August 3, 2006

RE: Vantage Bay Rezone (Z-06-25) and Preliminary Plat (P-06-26)

Grant PUD's review of the Vantage Bay rezone and preliminary plat has raised a number of broad issues as well as several specific review comments. From the broader point of view, Grant PUD has concerns about the following:

VANTAGE BAY, PLANNED UNIT DEVELOPMENT

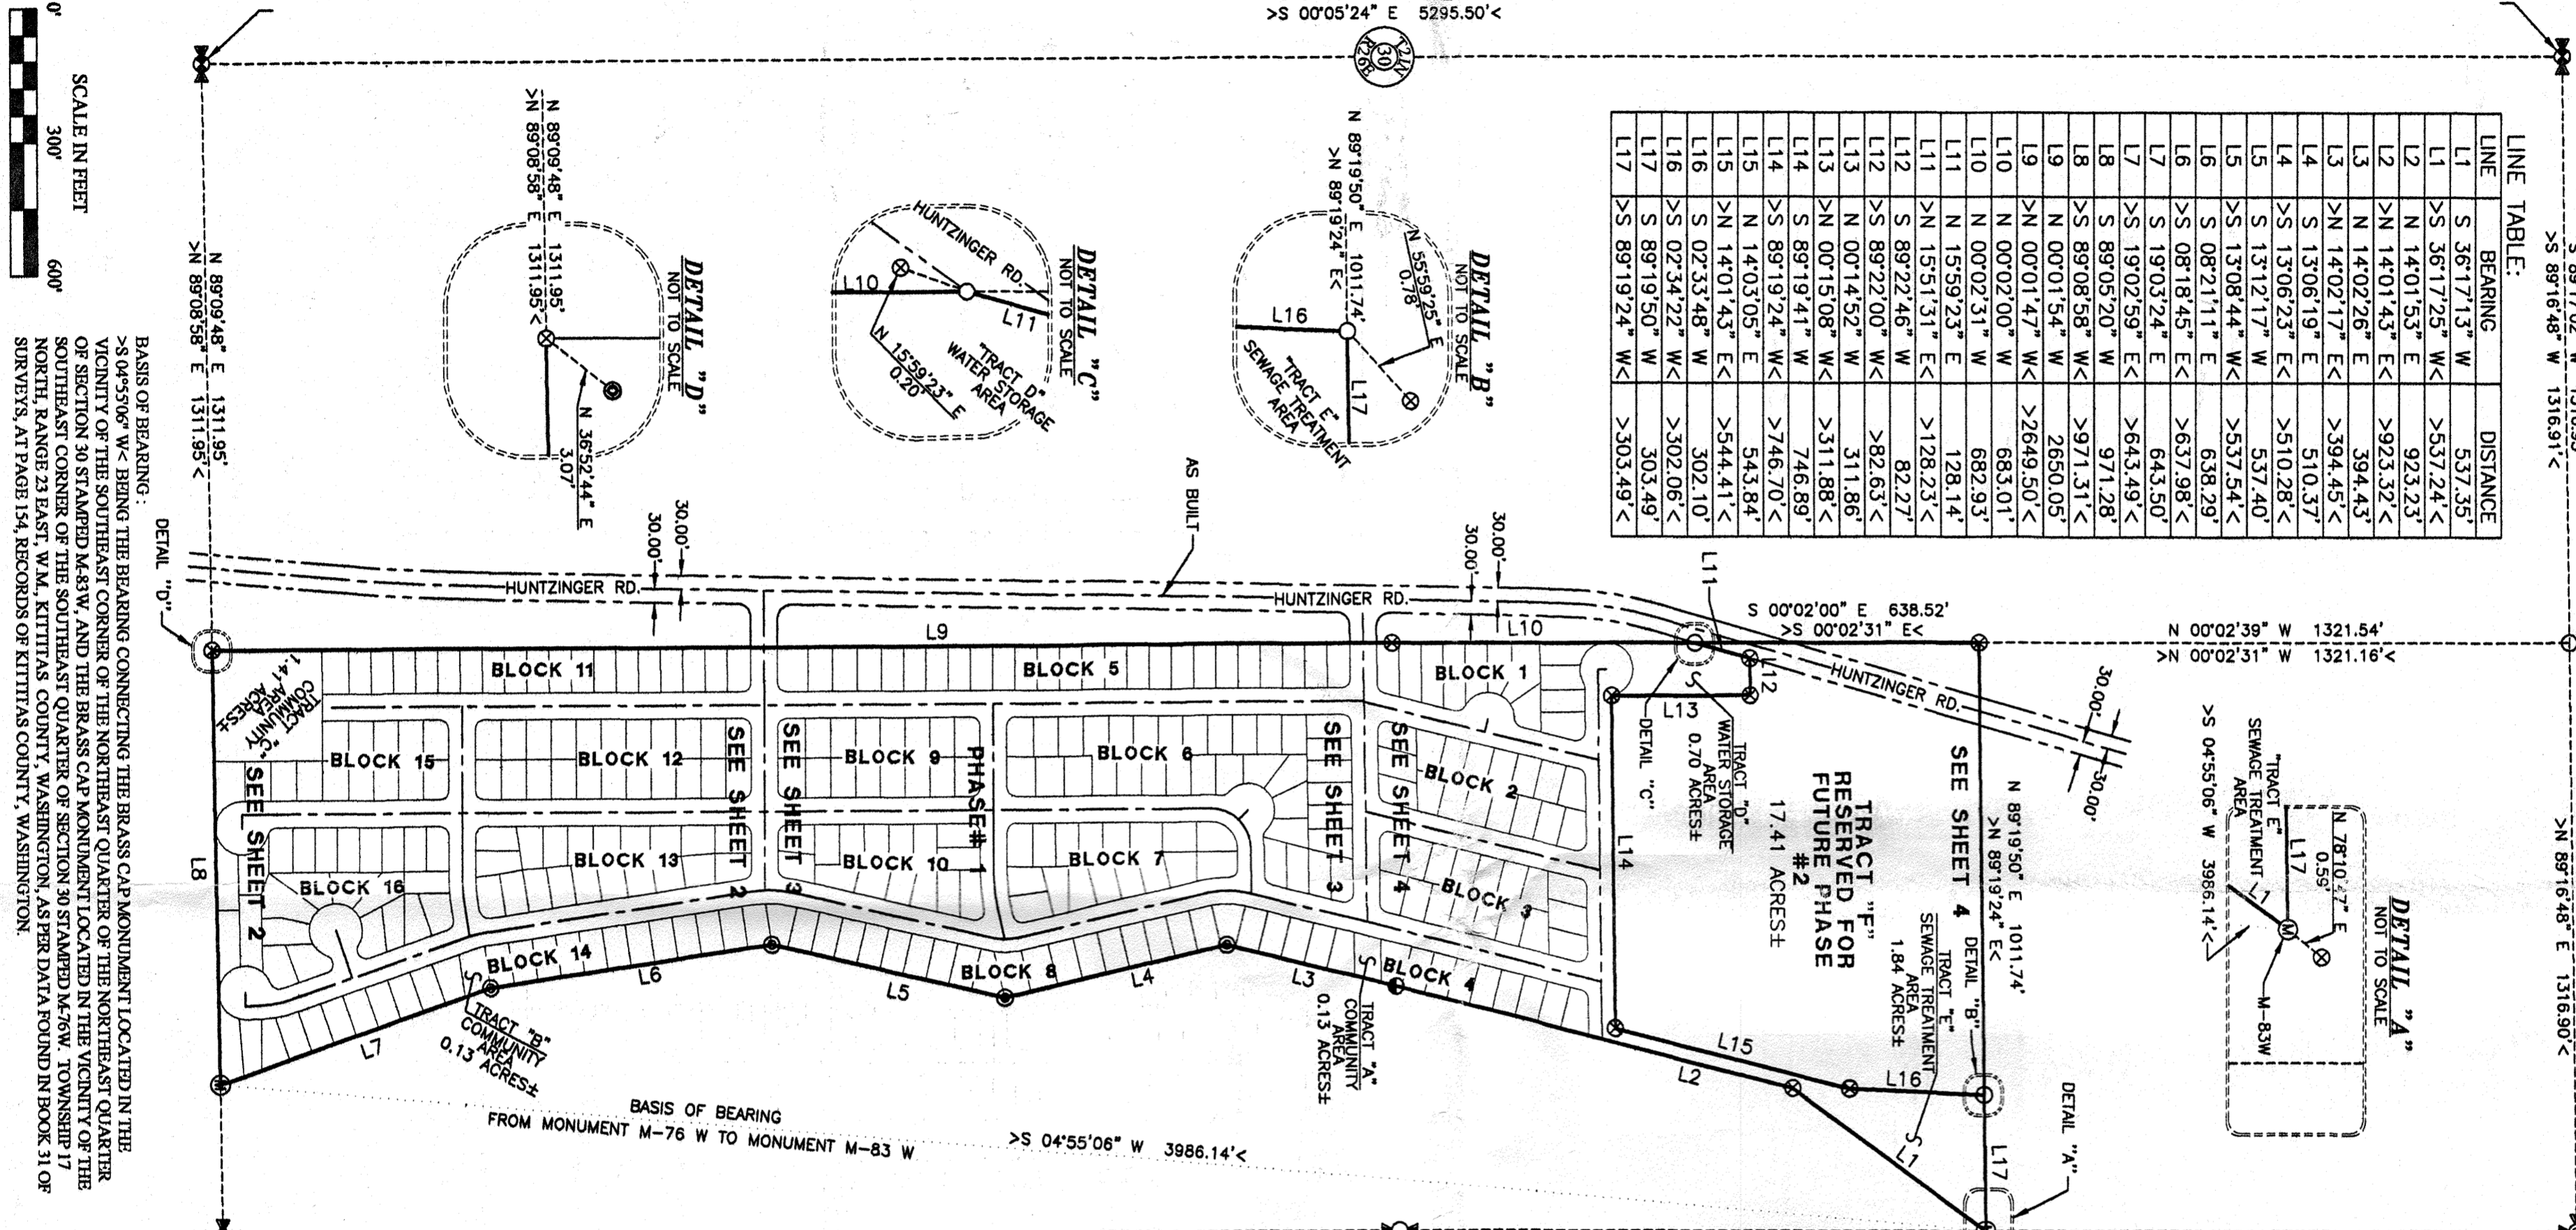
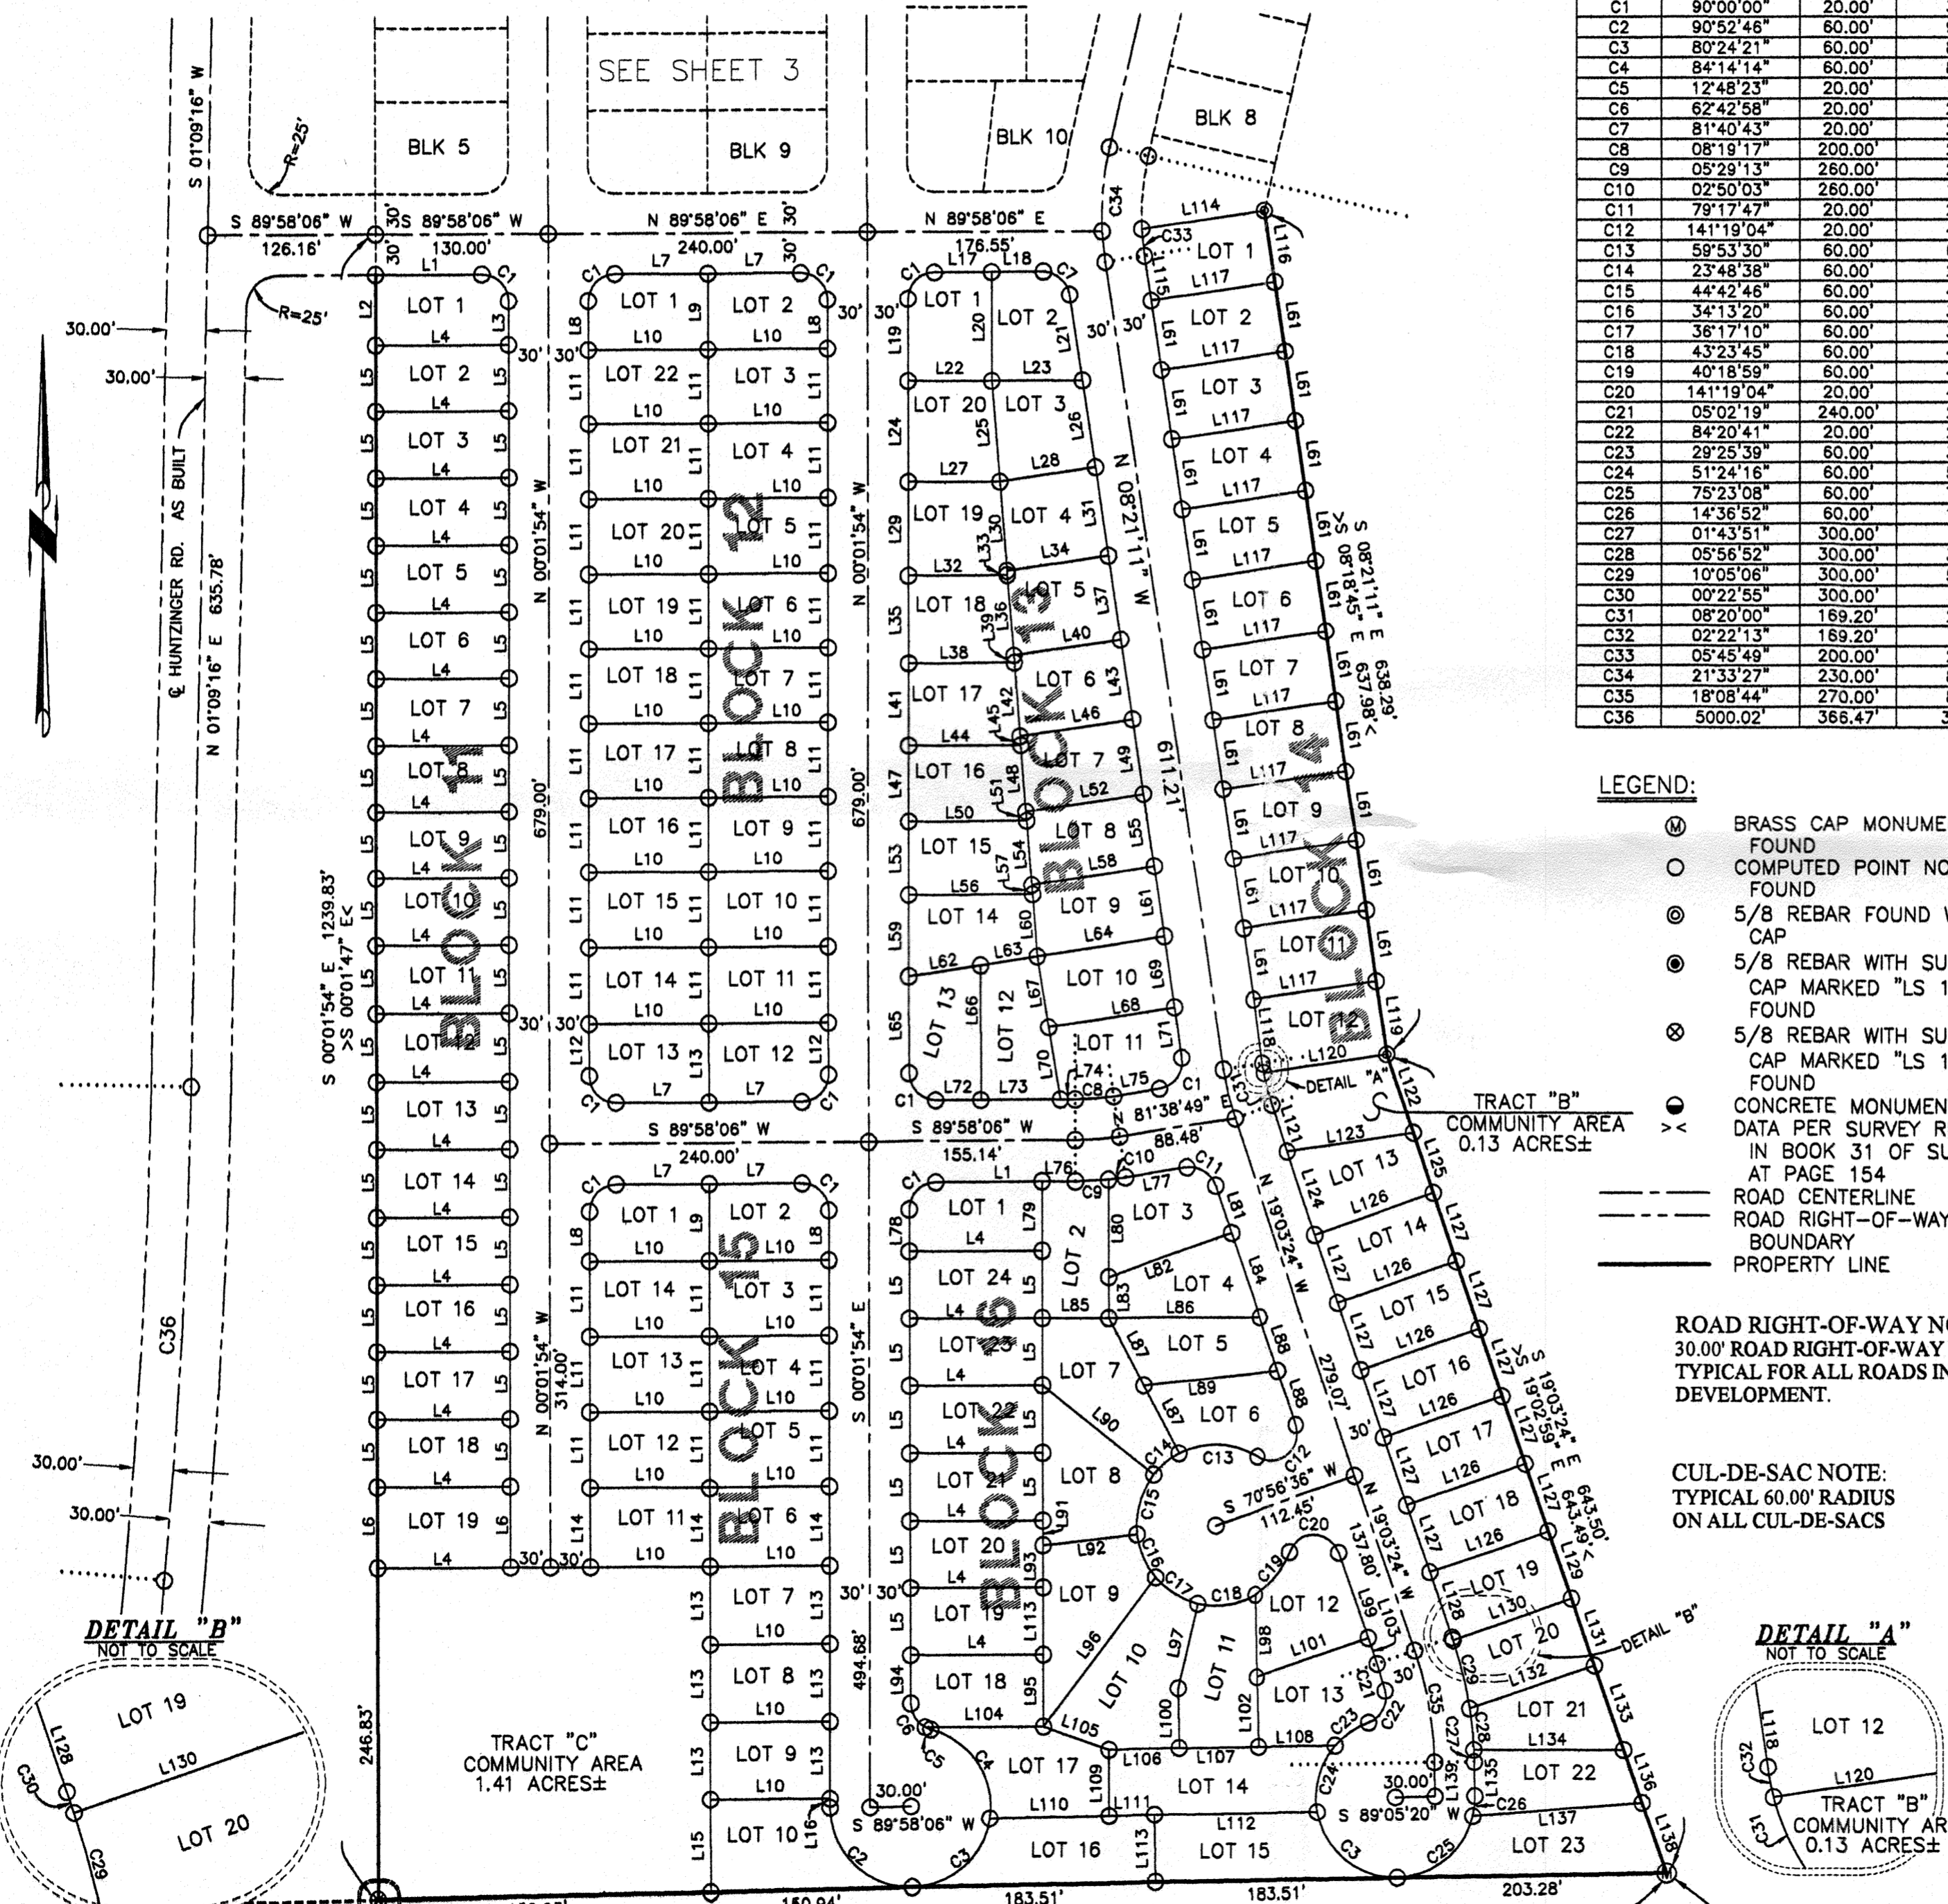
- The proposed location of the Tract A and Tract B Community Areas will provide access to the Grant PUD-owned shoreline. Shoreline uses are regulated by FERC and permits issued by Grant PUD will be required for any community access other than non-motorized undeveloped ingress/egress.

- Grant PUD requests dedicated public ingress and egress for motorized vehicle access over the road proposed to extend from Huntzinger Road to Tract A Community Area, and over the proposed Tract A Community Area.

- Grant PUD requests dedicated public ingress and egress for non-motorized trail access adjacent to the road proposed to extend from Huntzinger Road to Tract A Community Area lot, and over the proposed Tract A Community Area lot.

- Grant PUD requests a 10-foot wide unobstructed easement running parallel to the Grant PUD property line. This easement should be located within the plat on property owned by the developer and dedicated to community ingress and egress for non-motorized access to Tract A and Tract B Community Areas proposed in the plat. This easement will provide a community thoroughfare to the Grant PUD-owned shoreline properties for use as a non-motorized trail system.

- Grant PUD recommends installation of fencing delineating private and public property on the easterly property boundary to prevent future encroachment, and minimize ground disturbances and vegetation damage.

- The plat as proposed does not adequately address the storage and guest space needs of the lots. The lots as proposed are scarcely large enough to build a single-family house, to say nothing of the guest parking, boat storage, and other space needs that will surely accompany second-home, resort residential development.

- The proposed lot sizes in the plat are not in keeping with the open, natural appearance of the Vantage area, especially the adjoining public lands (Grant PUD and Washington State Parks).
